Recommendation Report for Planning Permission for Works or Extension to a Dwelling

REF NO: AW/295/18/HH

LOCATION: 9 Aigburth Avenue
Aldwick
PO21 3DA

PROPOSAL: Conversion and extension of existing garage to craft/store and demoliton of existing conservatory to include alterations to fenestration

Itemref	Quantity	Title/Name, designation, material, dimension etc			Article No./Reference	
Designed by jd	Checked by XXX	Approved by - date	Filename	Date October 2018	Scale 1:50	
9 Aigburth Avenue				Proposed Alterarions		
				04	Edition 0	Sheet 1/1

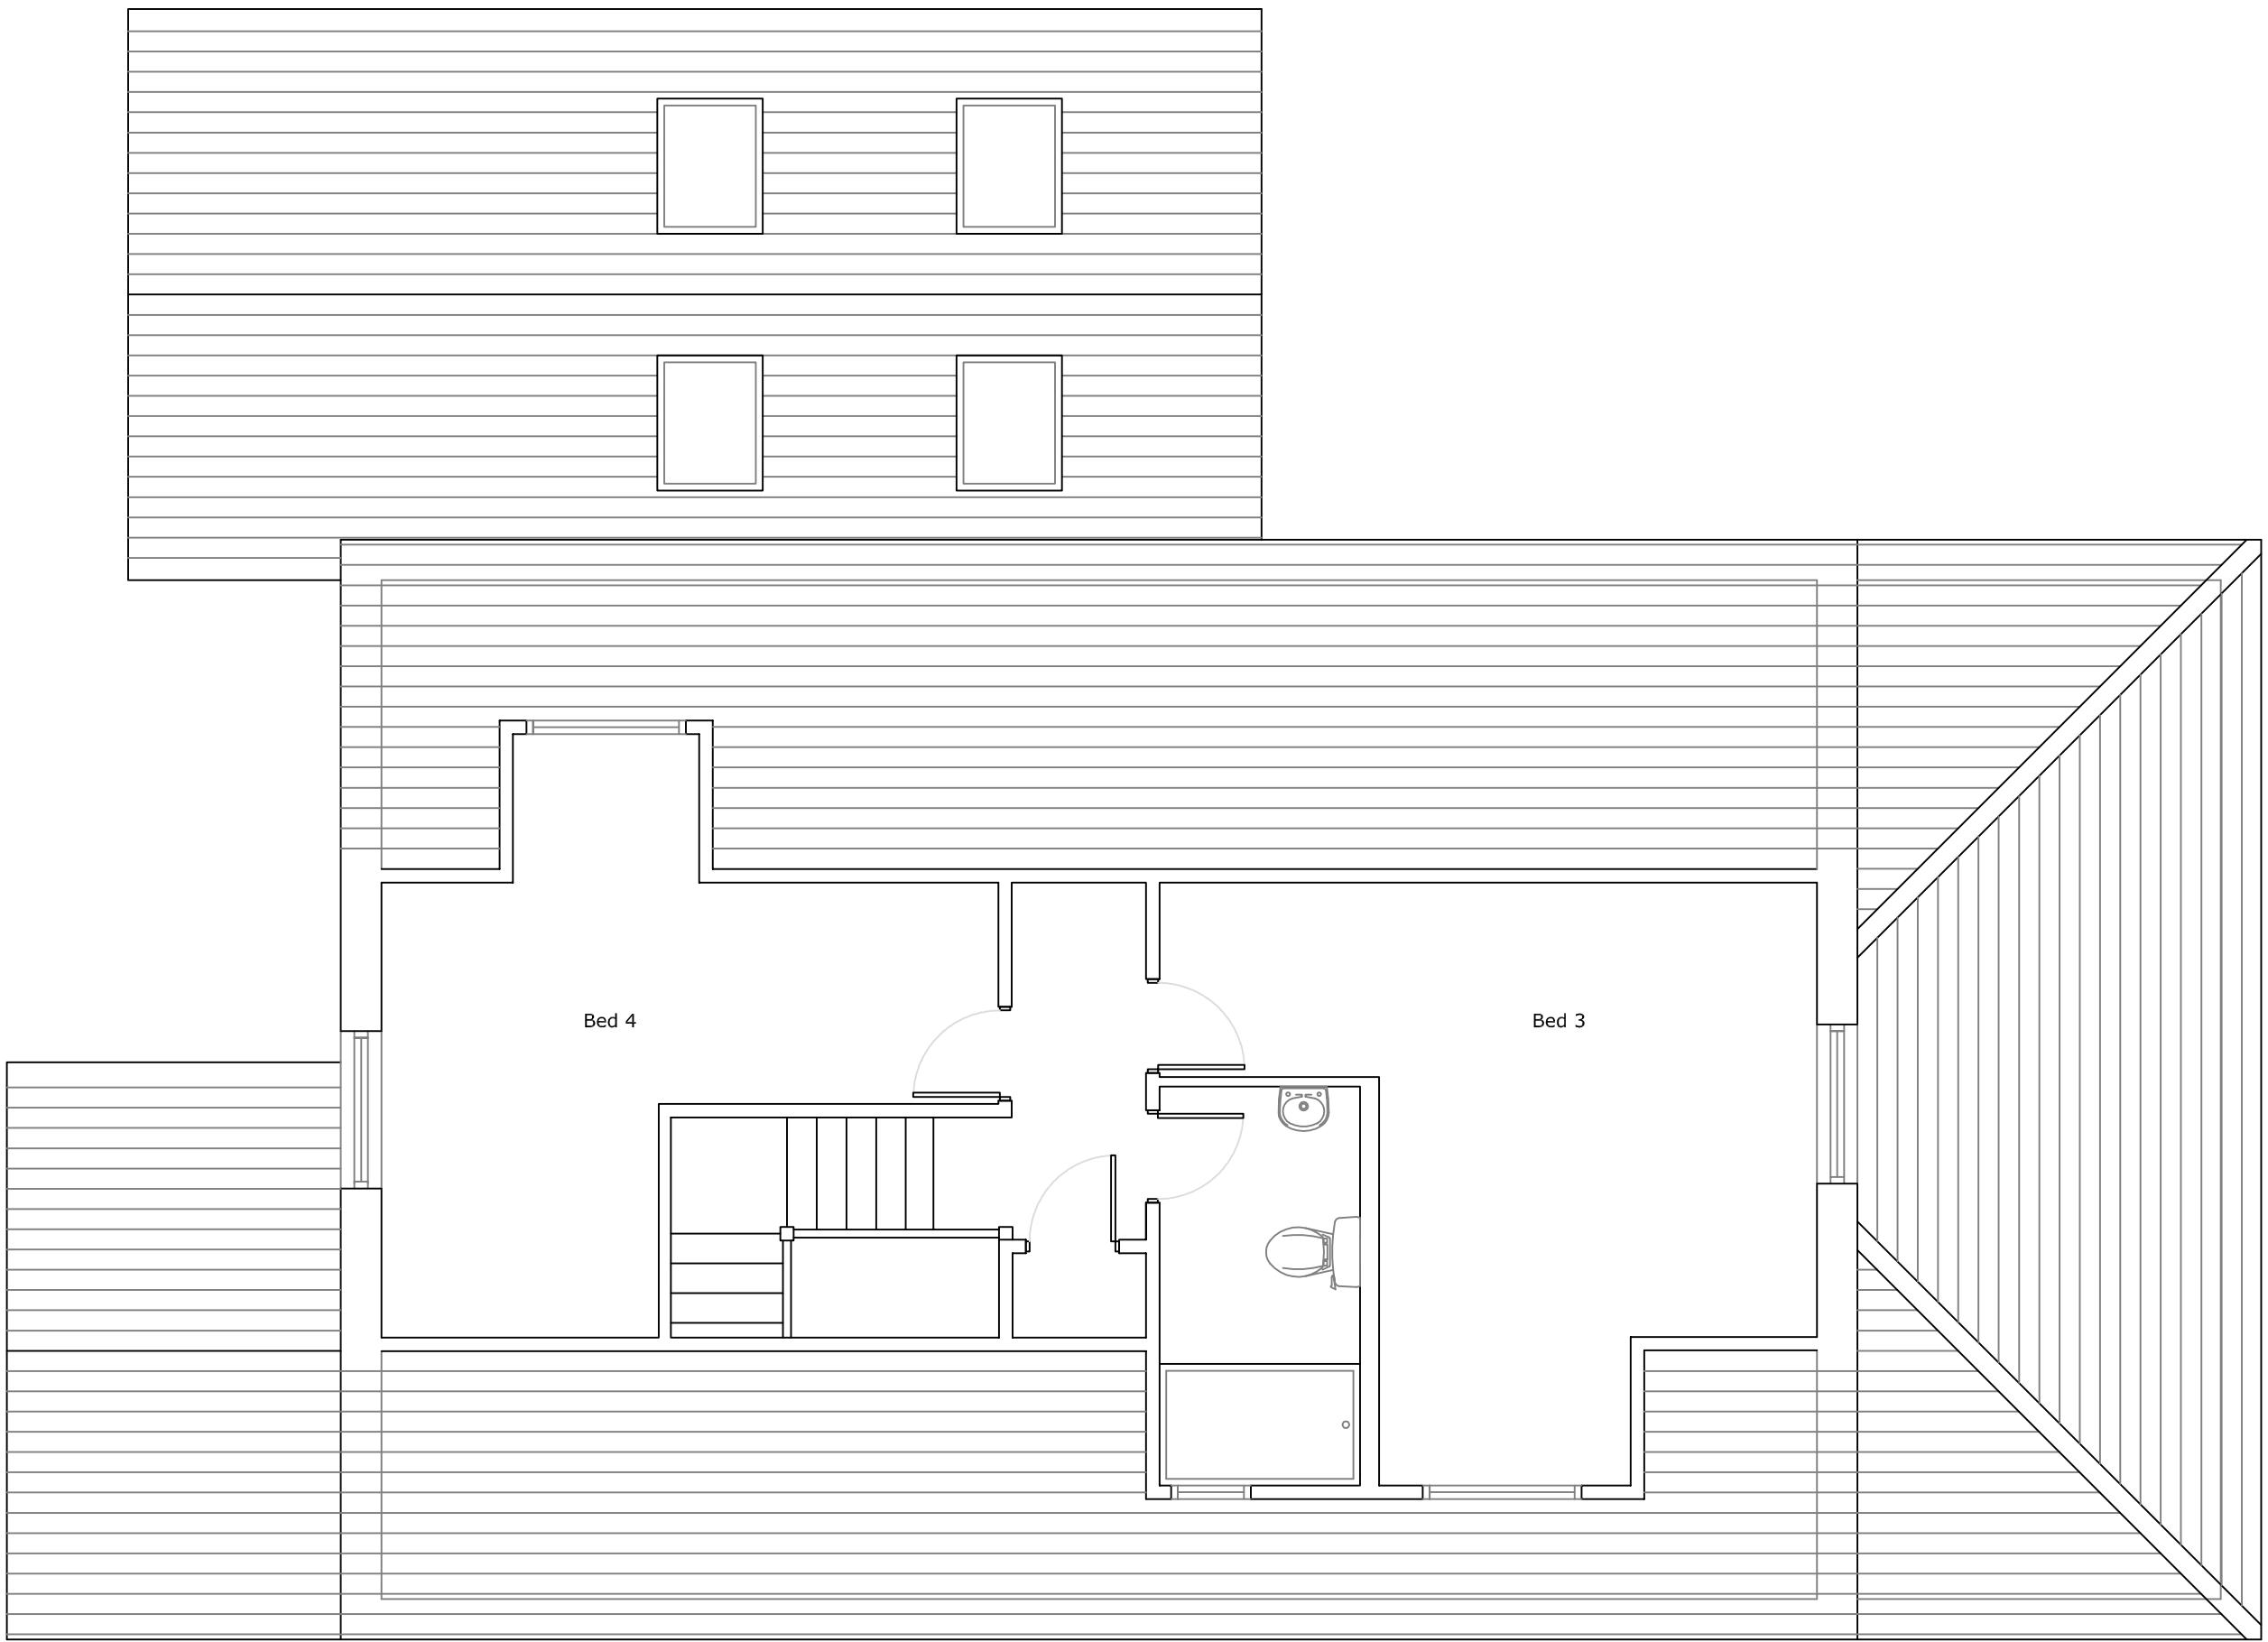
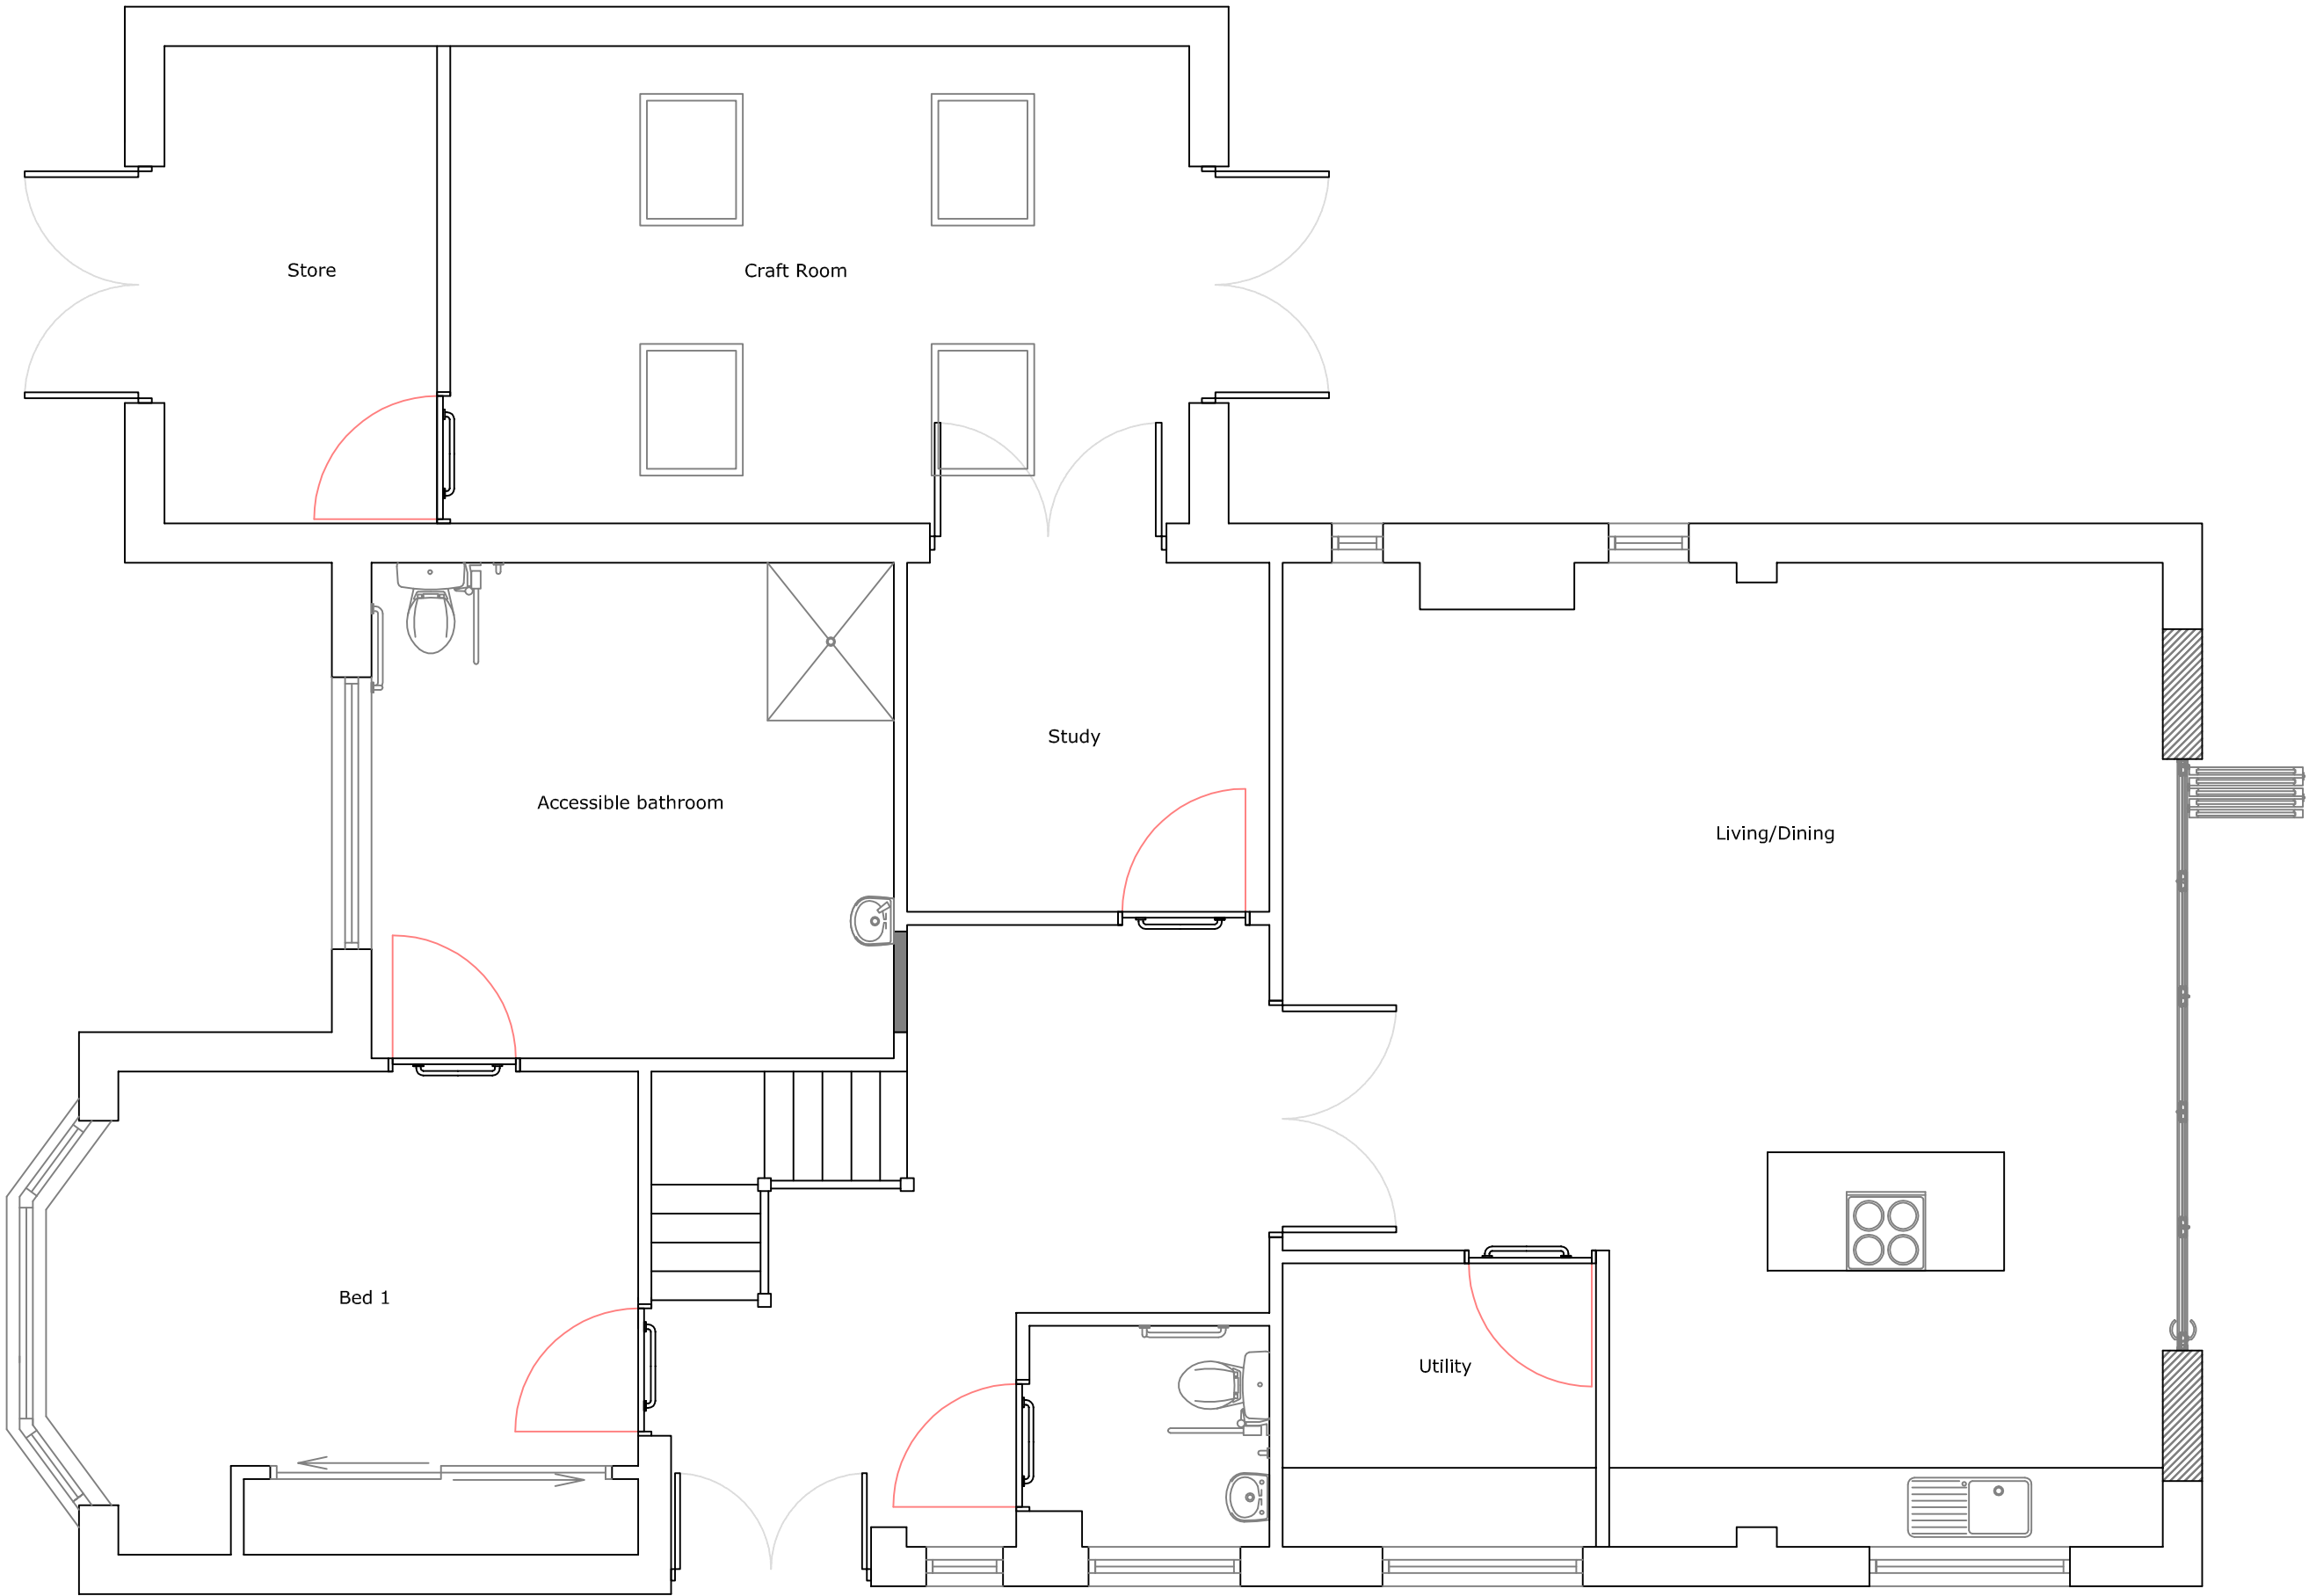
The proposed conversion and extension of an existing garage to craft/store is situated at the rear of the property. The proposed extension and conversion of the existing garage is located to the rear of the property will extend by approximately 2.2m in length, 3.8m in width and be built to a proposed height of 4.5m.
